RE: SUB17-006 & SUB17-007 Corrections, and Public Sewer Easement Extinguishment

Conard Romano Architects has reviewed the comments raised by the City of Mercer Island Development Services for the proposed project at 8000 SE 20th St. Our responses have been provided via the MlePlan Cloud file and are also addressed in the attached drawings.

PRELIMINARY
NFH RESIDENCE LOT LINE REVISION
(LOT CONSOLIDATION)
 POR. OF GOV. LOT 1, SEC. 1, TWP. 24 N., RGE. 4 E., W.M.

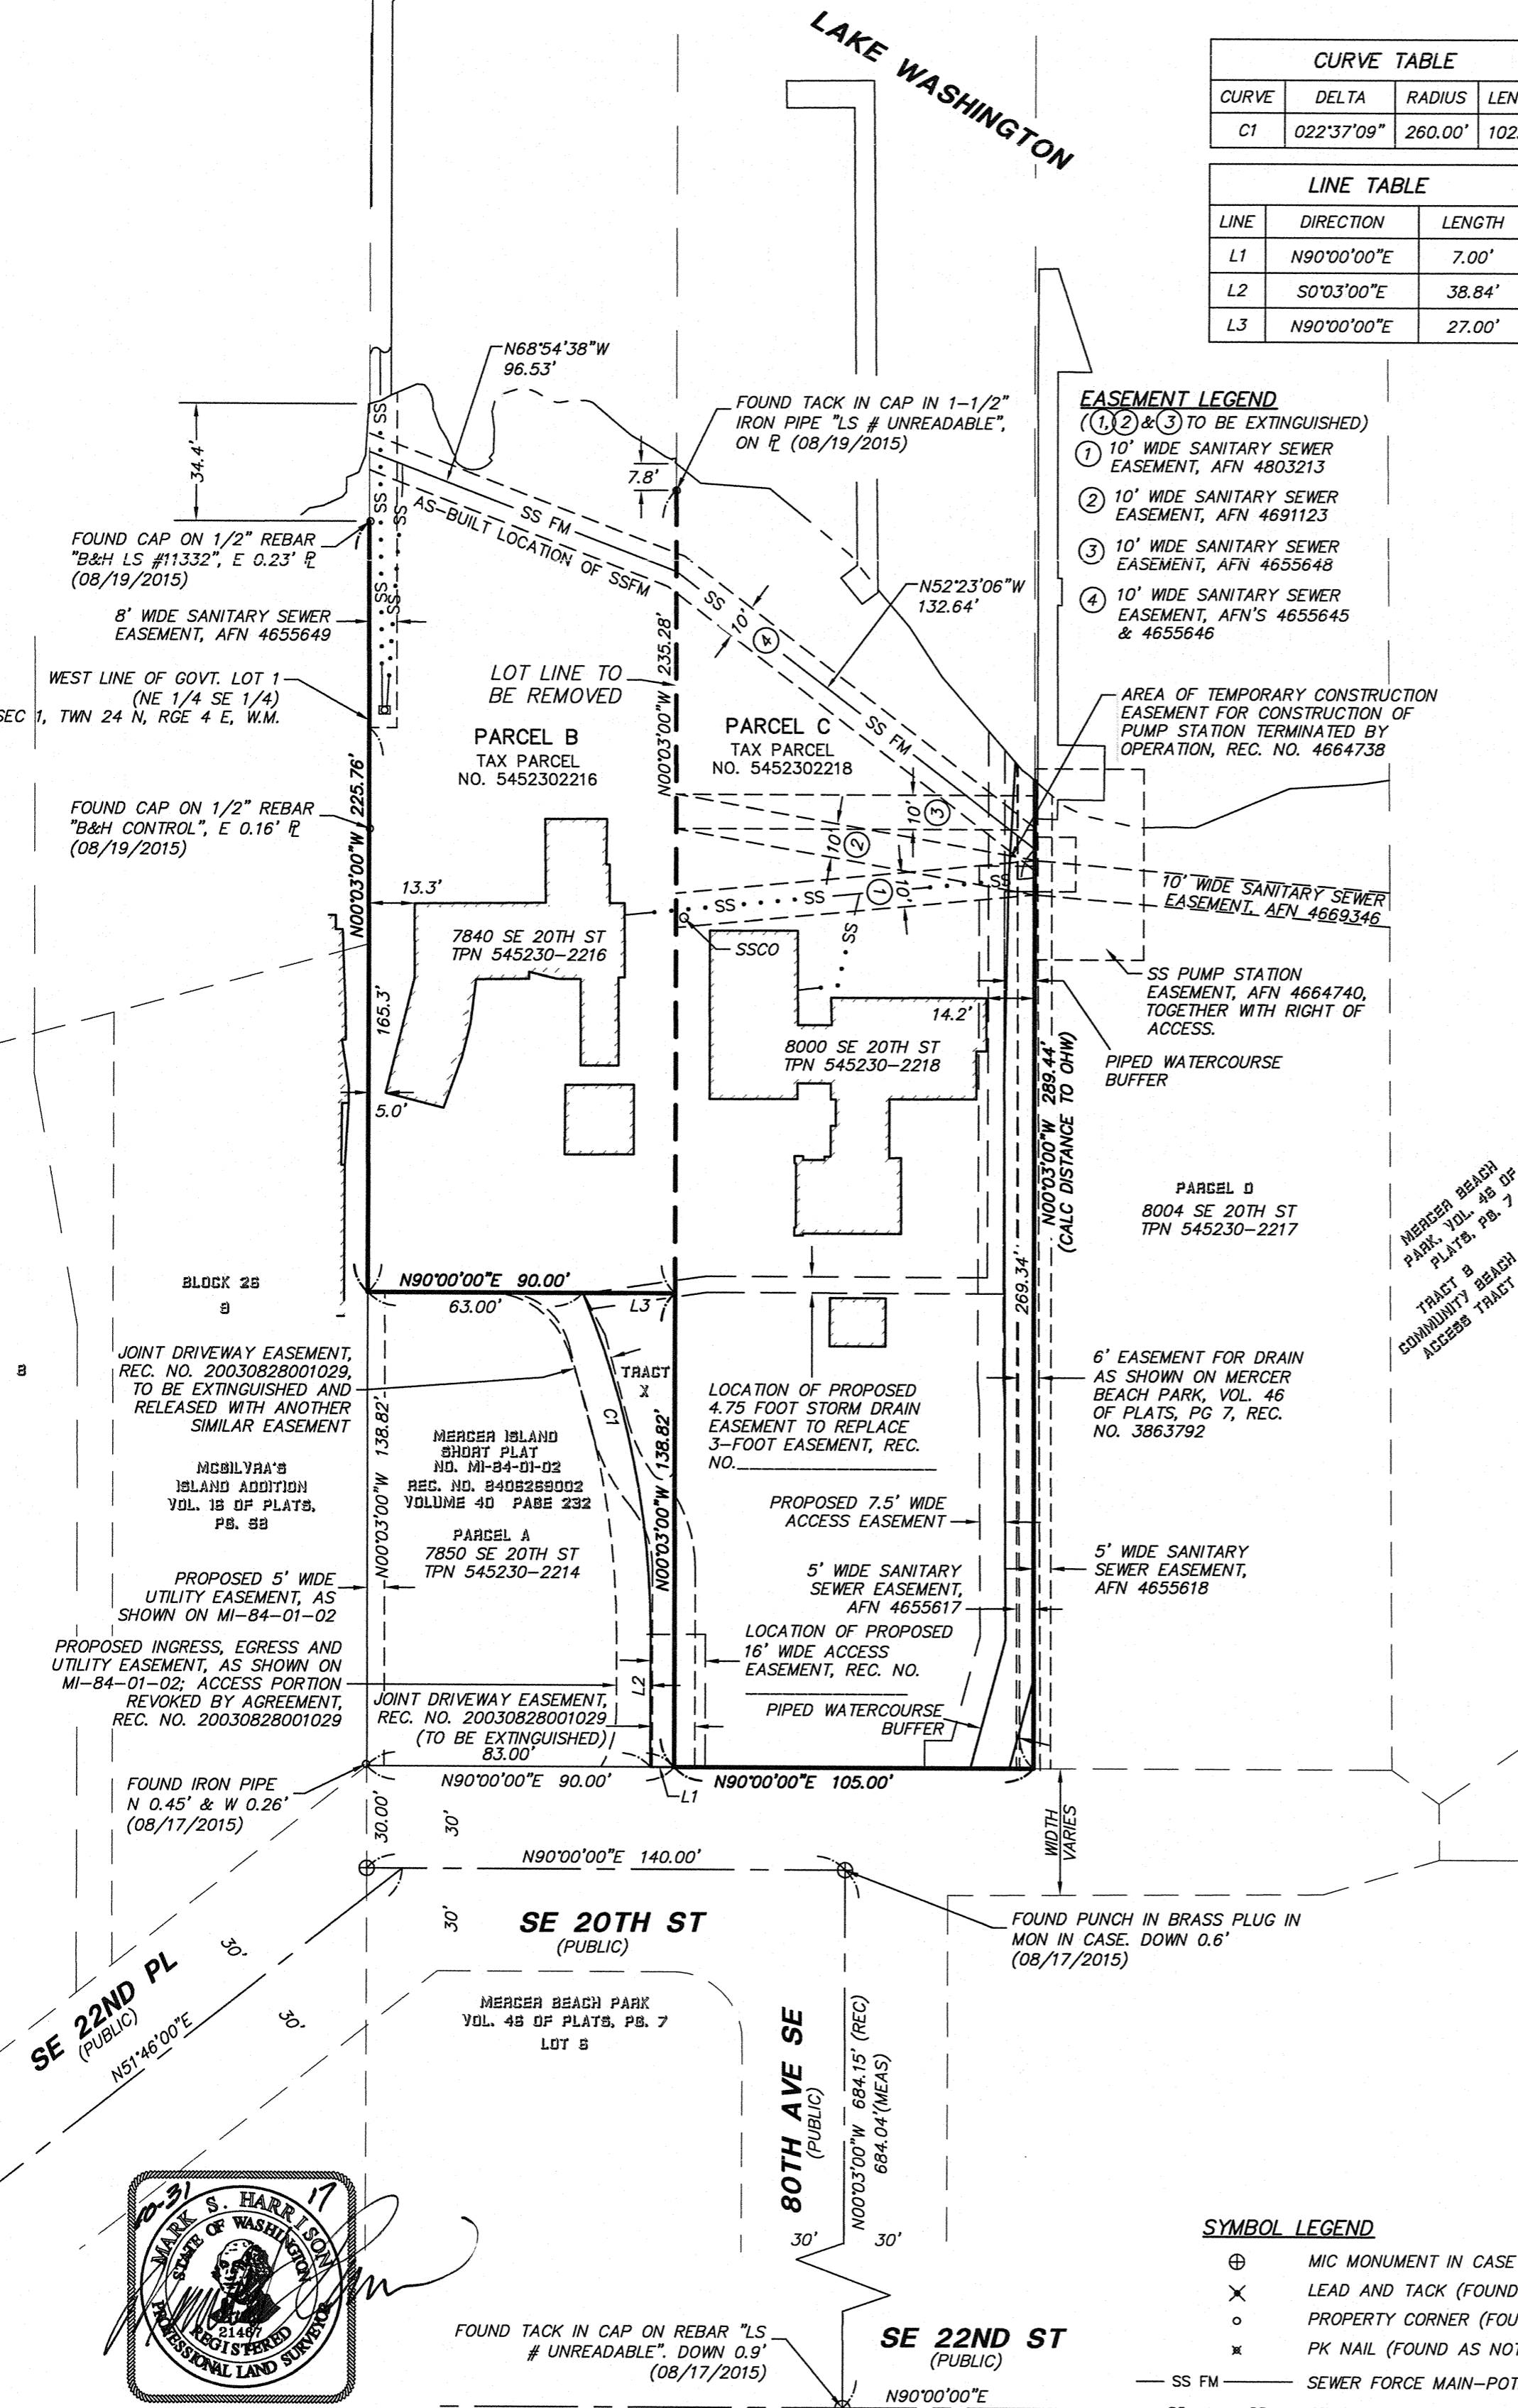
- The SSFM line along the shoreline has been located and surveyed. This information has been added to the plans associated with SUB17-006 & SUB17-007. The proposed beaches and stairs will be adjusted as needed to remain outside of the easement.

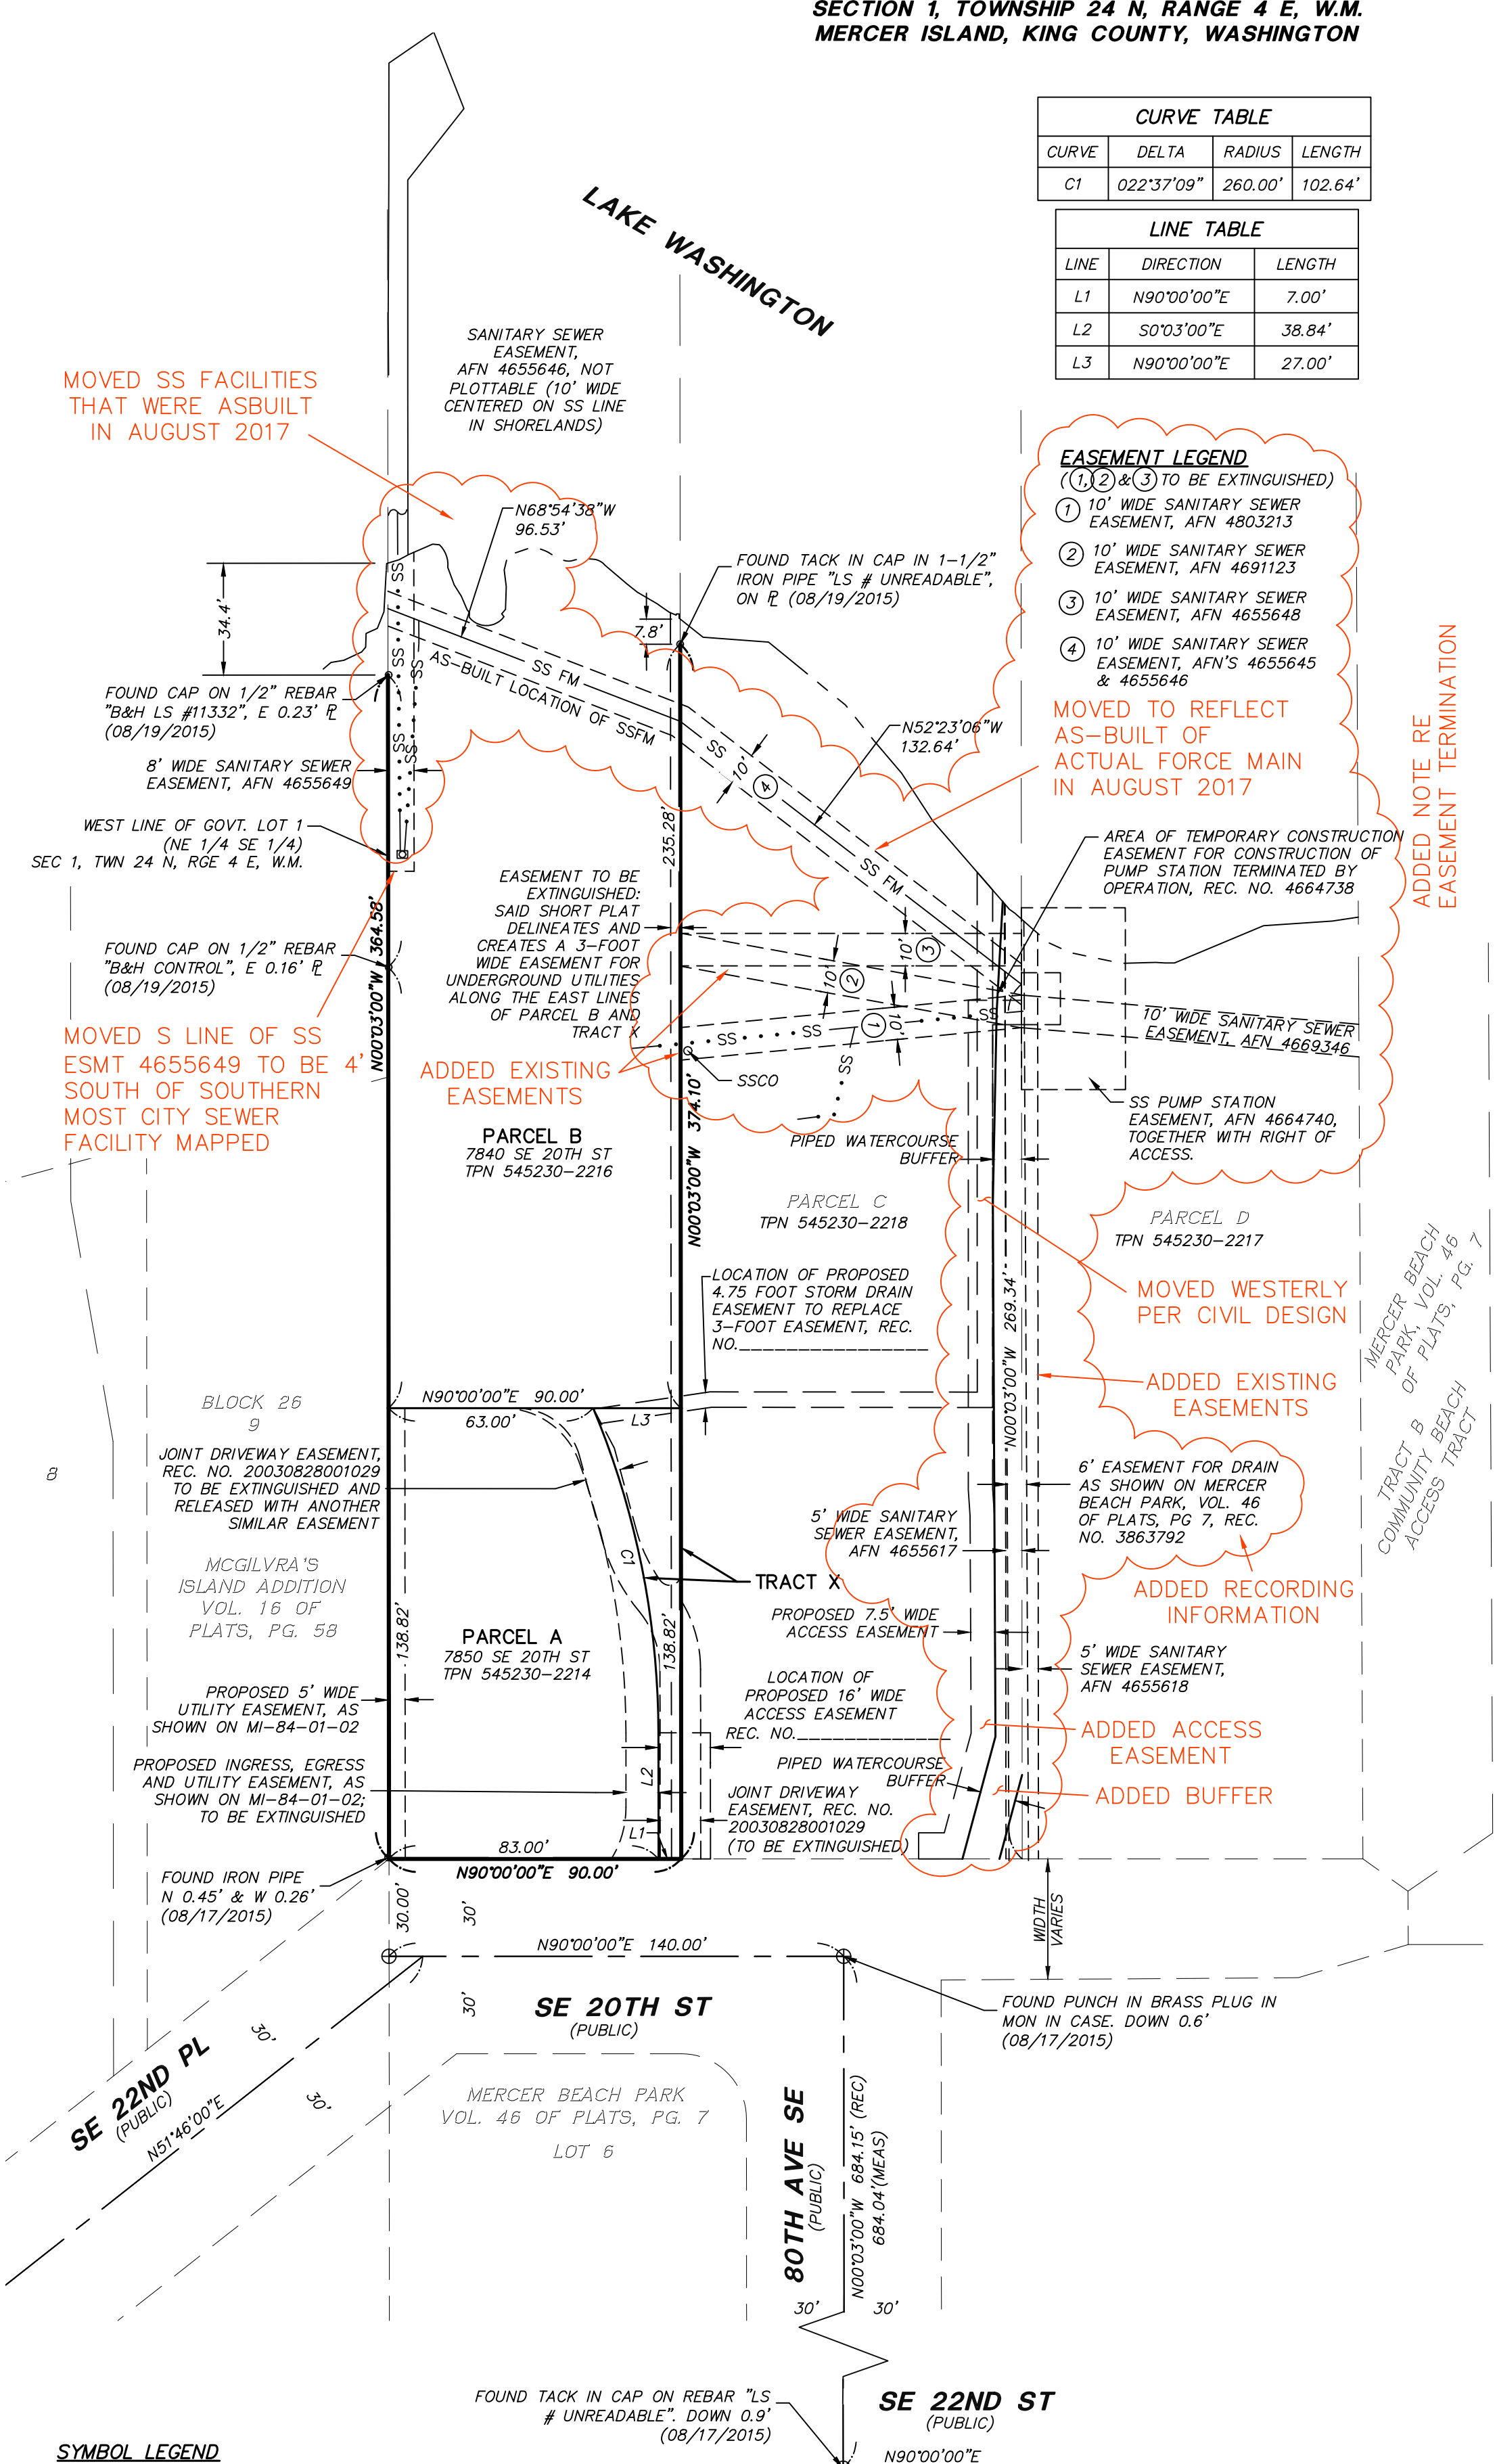
- The recording number of the “6-foot easement for drain” has been added.
- The updated title report for SUB17-006 has been included with this submittal. The identified exceptions (Schedule B) are identified on the plans with the associated recording numbers.
